Ref. 23296.

4th March 2024.

Re: ABP – 318505-23. Carrownagowan 110kV Grid Connection - Futureenergy Carrownagowan Designated Activity Company (DAC)

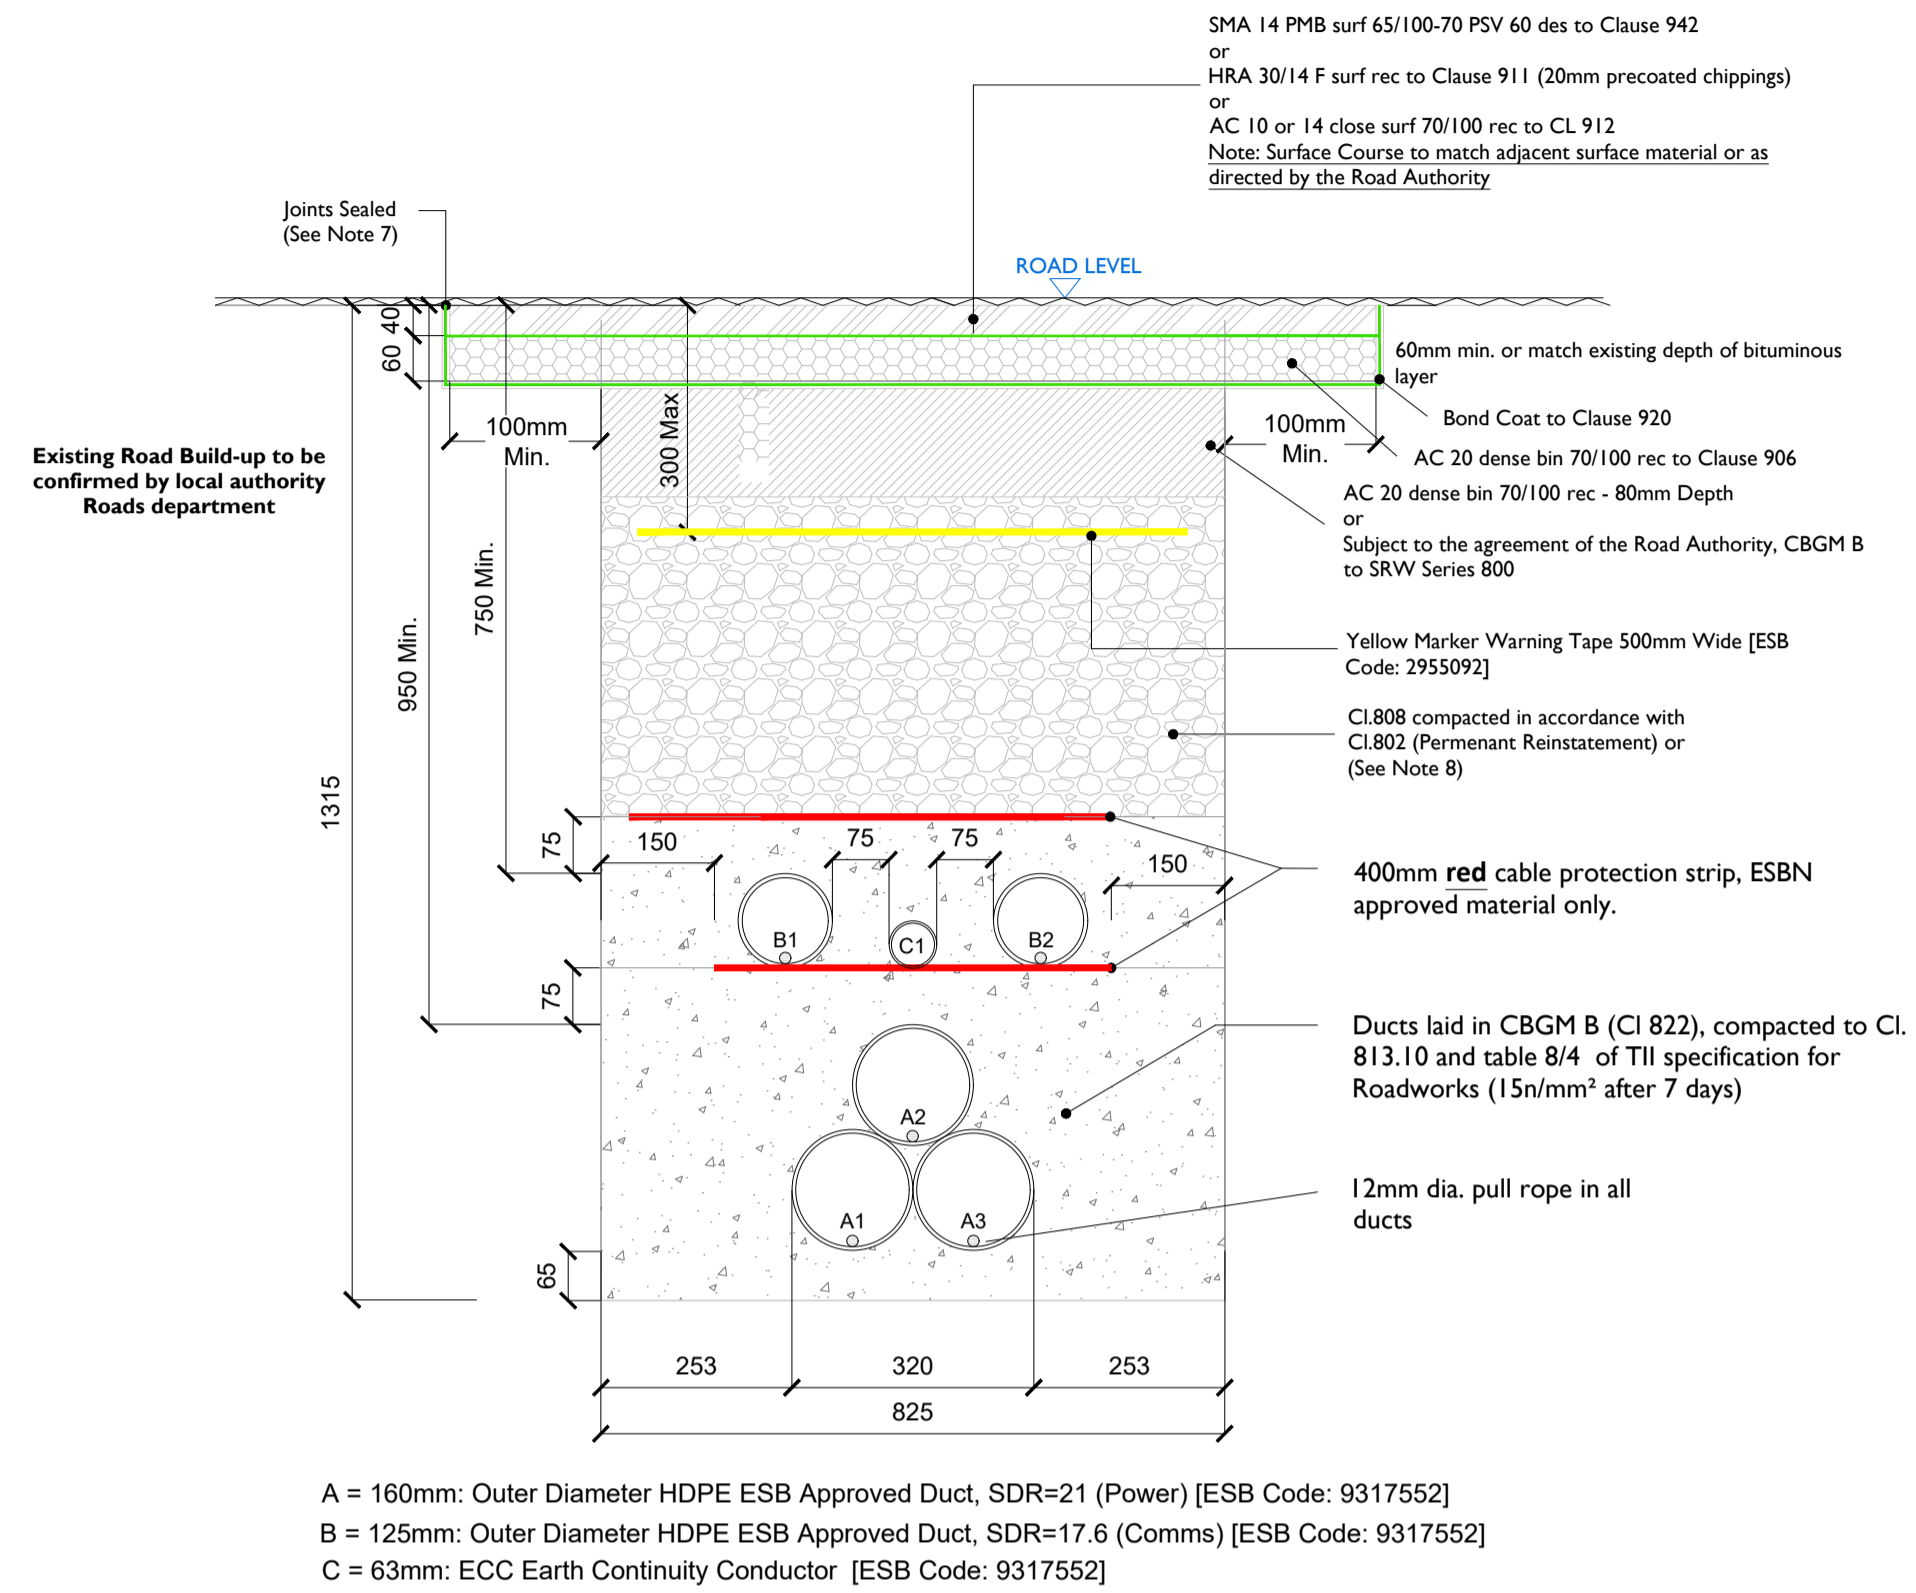
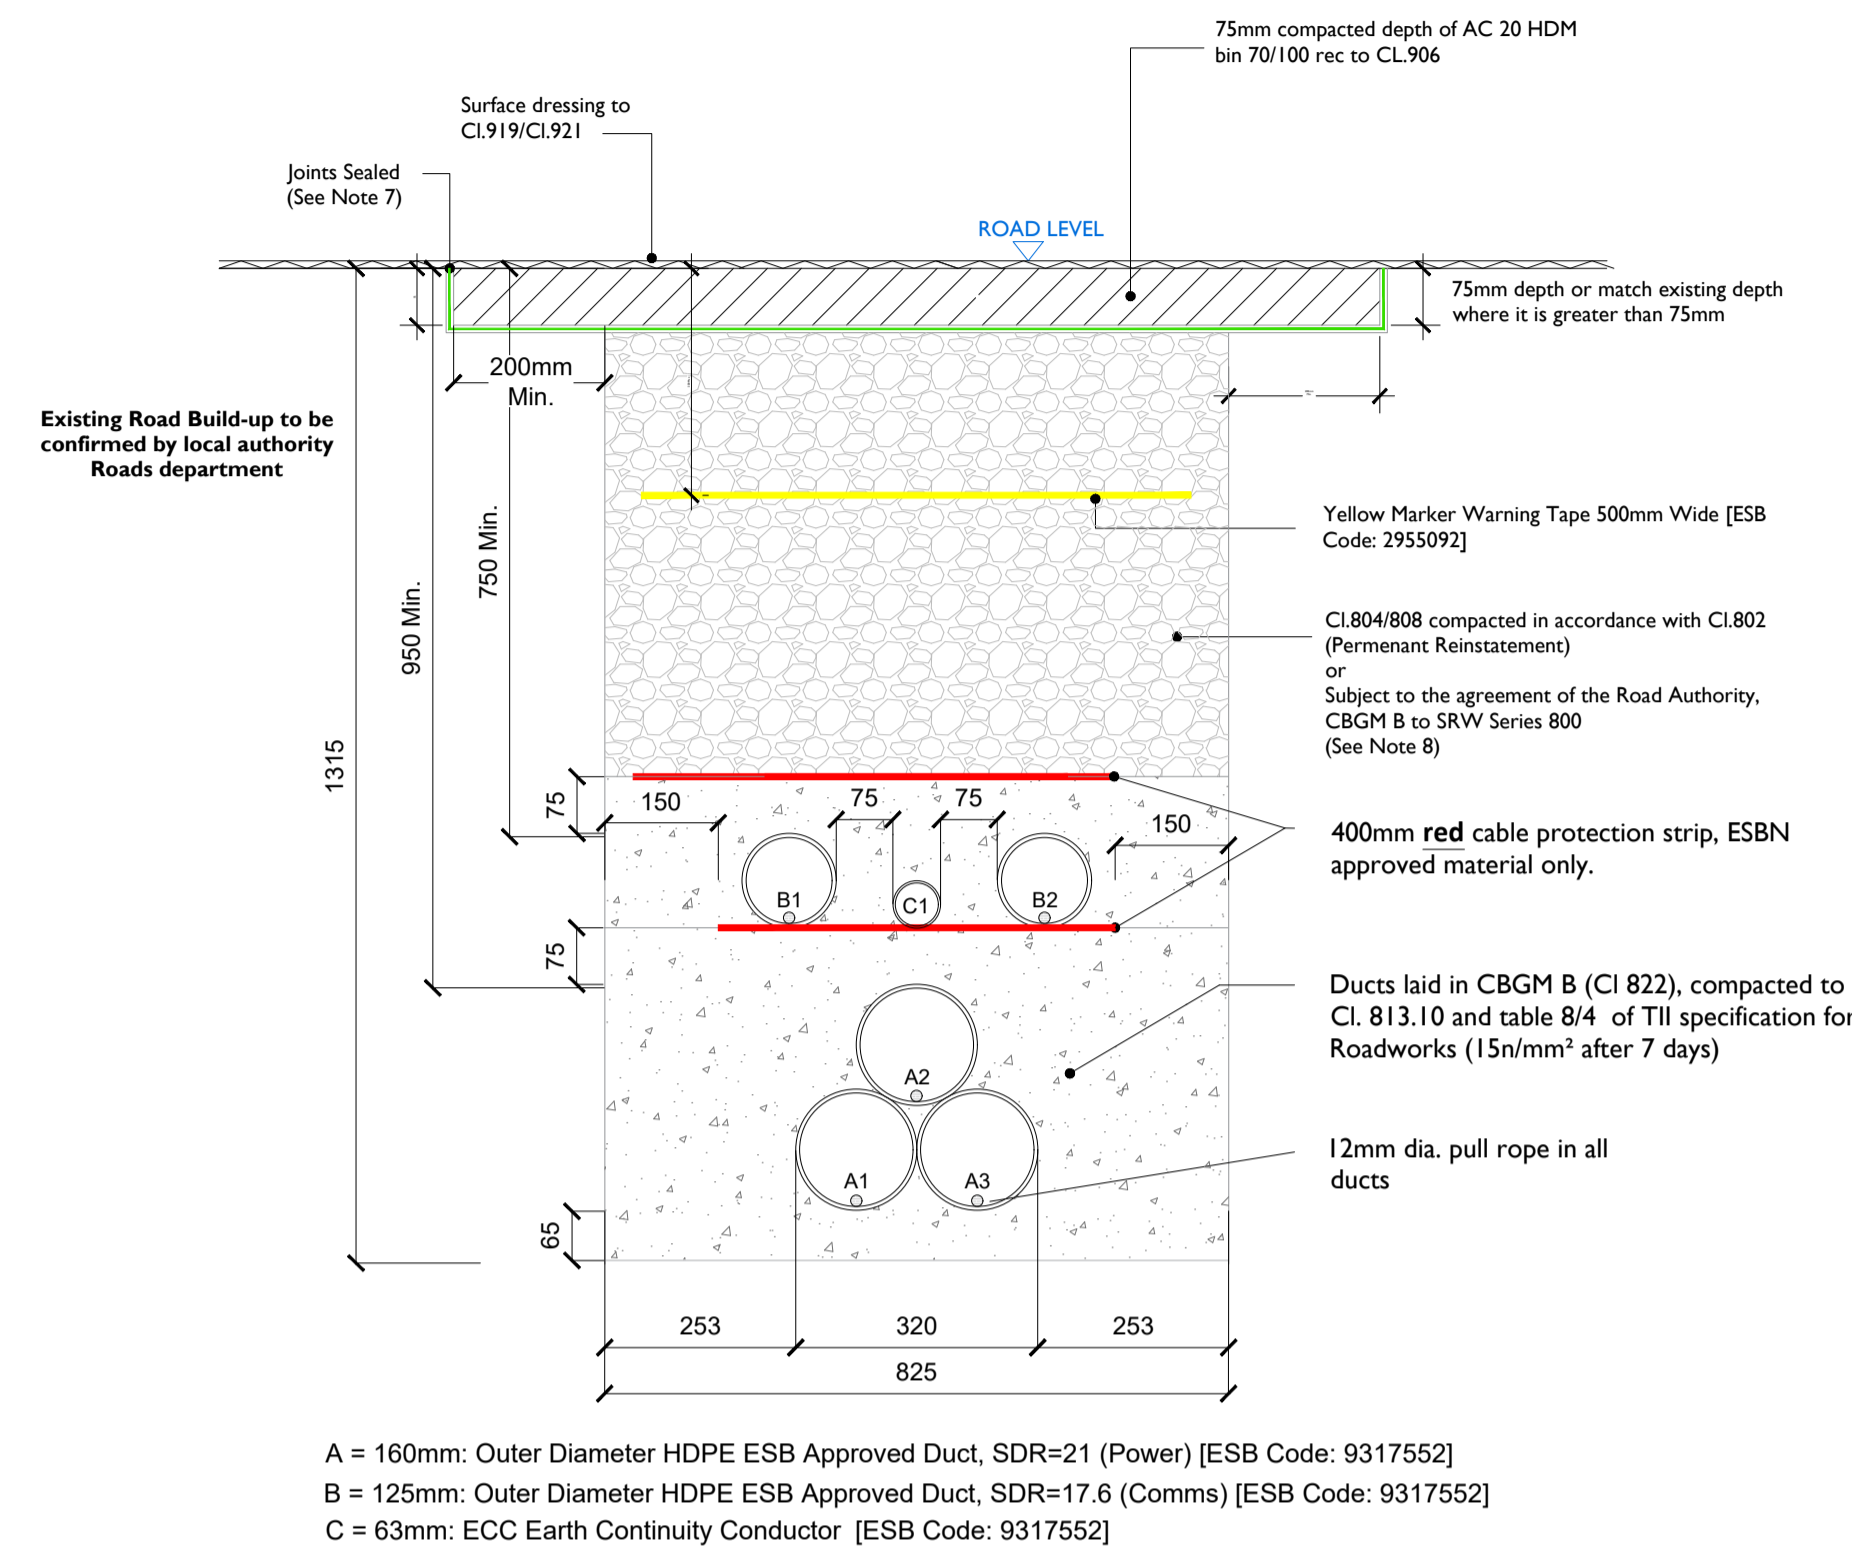
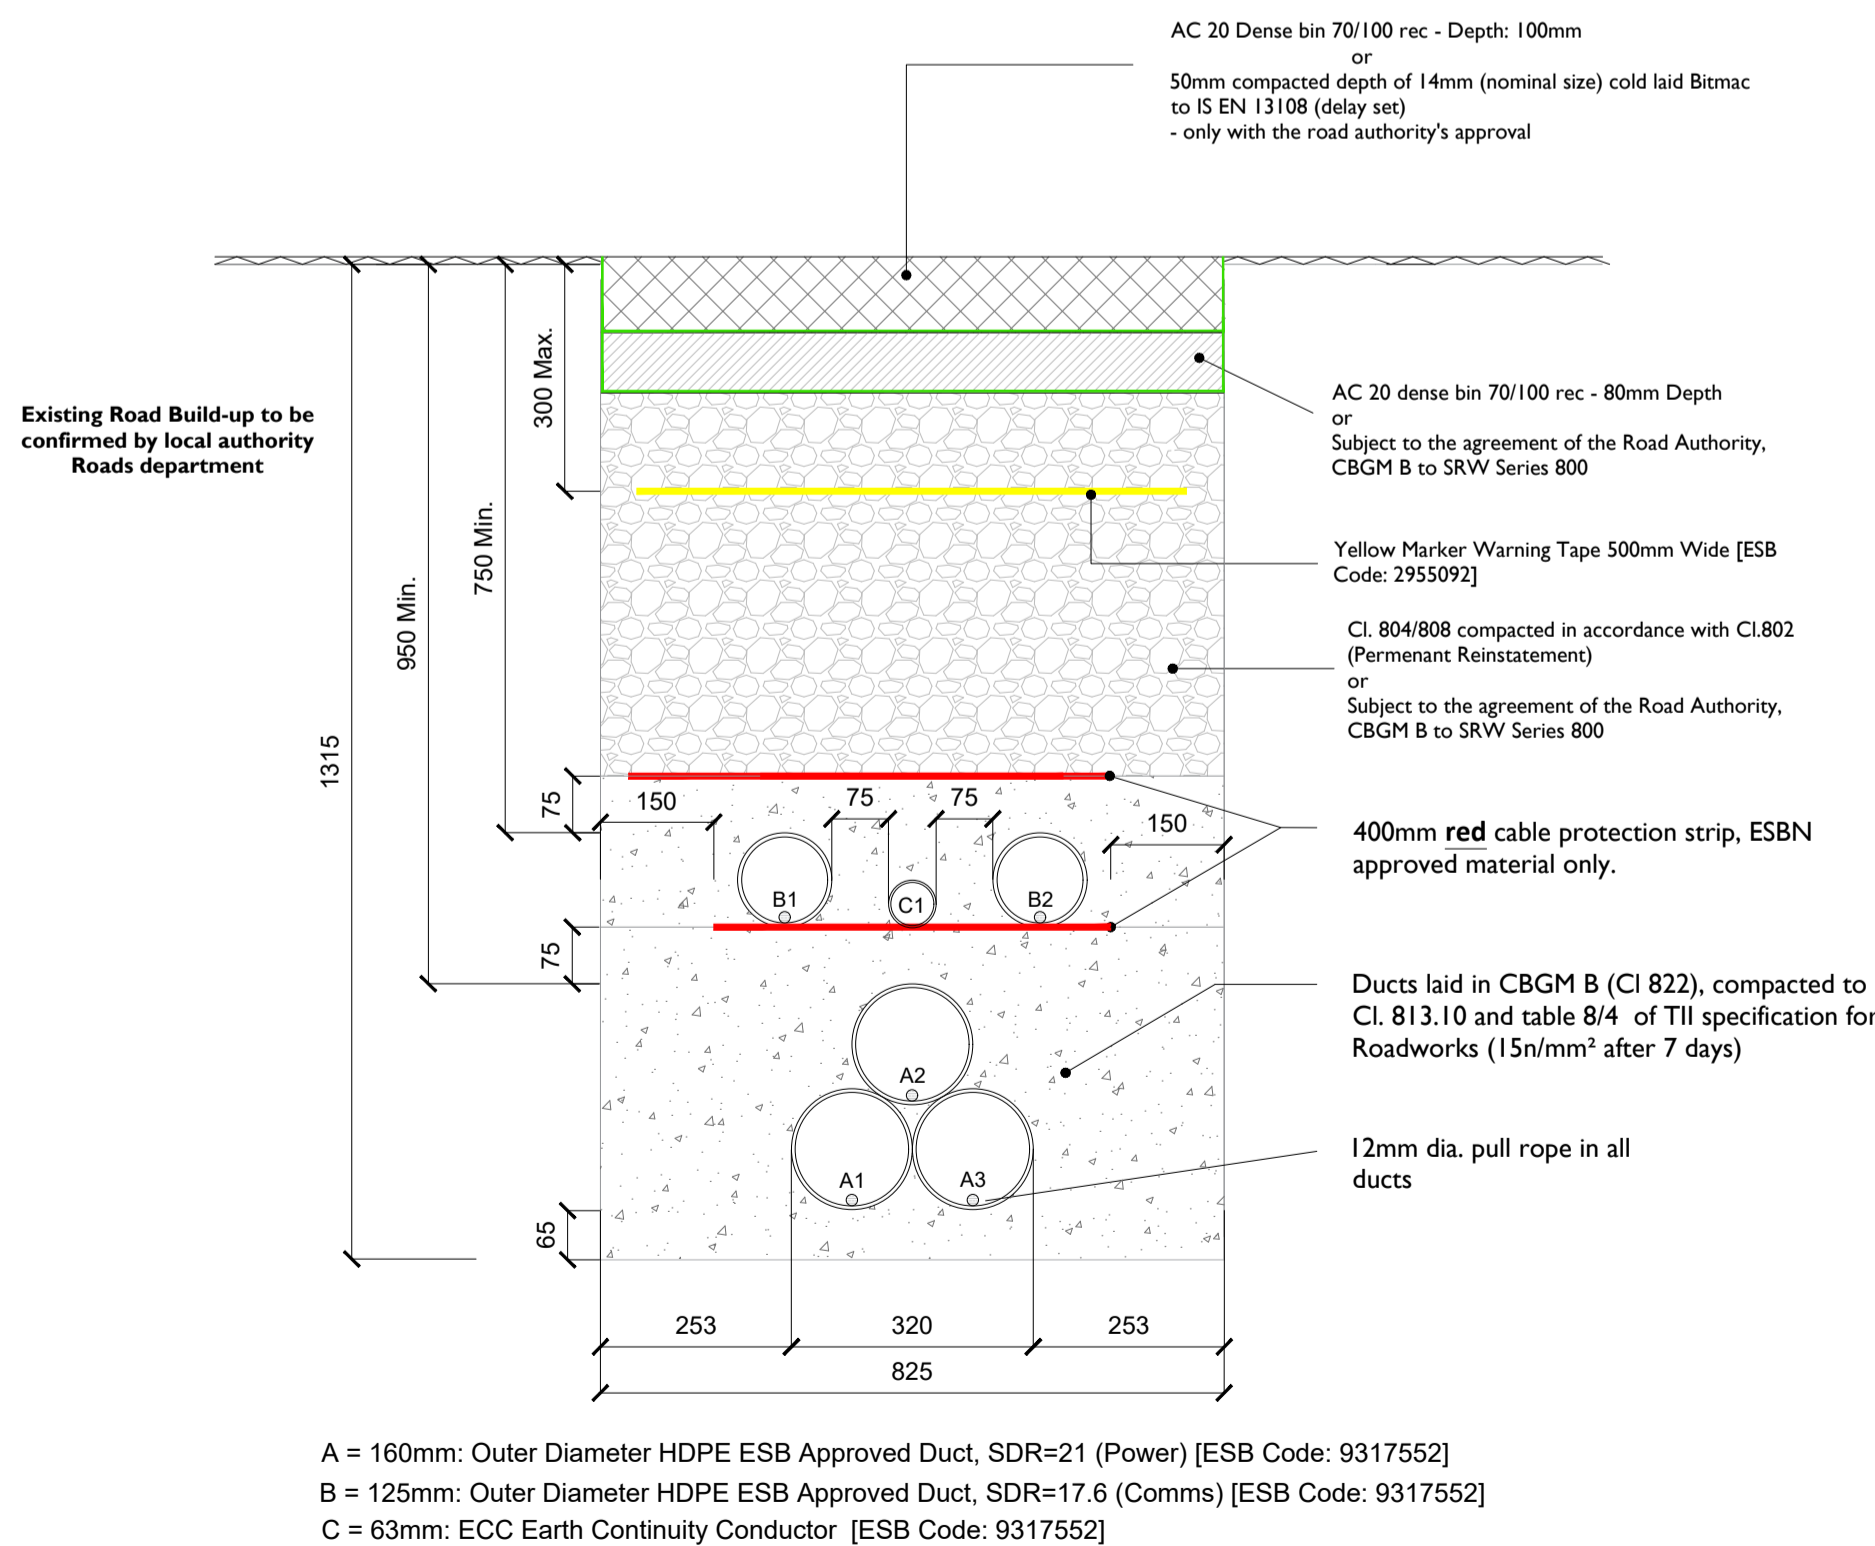
The materials used in construction of the grid route are shown on Drawing Number 05641-221 and 05641-222. The specification for materials is set out in the EIRGRID specifications for 110kV underground grid routes. The drawings referenced above show the sectional layout of the trench and shows the PVC ducts installed along with bedding and surround, protection tapes and finished road surfaces. The materials used do not include lead materials.
